State Significant Development – Director-General's Requirements Urunga Antimony Plant Remediation Project (SSD-5357)

Re: Urunga Antimony Plant Remediation (SSD 5357)

EPA Review of the Project Application

Urunga Antimony Processing Plant Contaminated Site – Project Application & Preliminary Environmental Assessment, prepared by Department of Primary Industries, Soil Conservation Service, June 2012.

Figure 4 Site Location

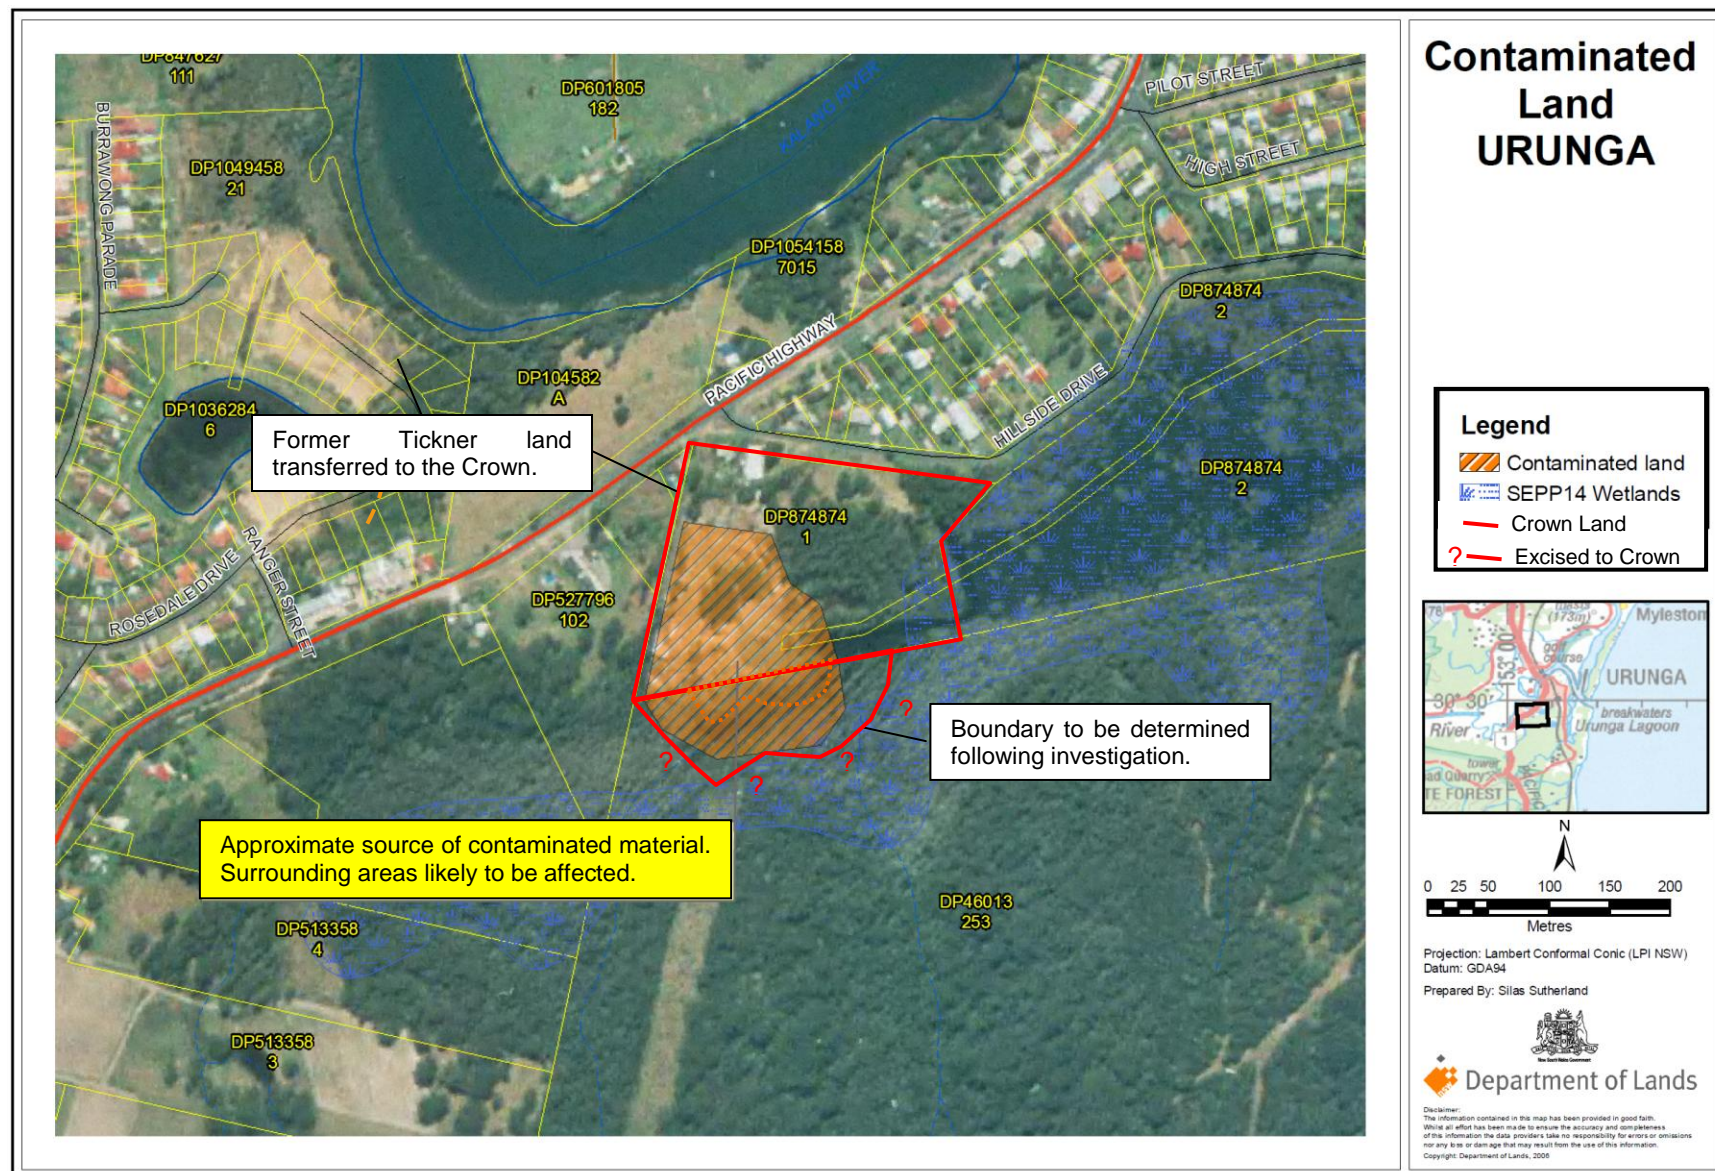
Figure 4 includes the north-west corner of the site as part of the remediation site. We note that this part of the site is not currently regulated as a declared area of significant contamination under the existing Management Order. The PA should note that this part of the site is not regulated and describe the area as potentially being utilised as part of the remediation process. The north-west corner of the site may be proposed as the location of a containment cell. This should be clearly presented in the PA so that the Planning Approval allows for utilisation of this area as part of the remediation of the site.
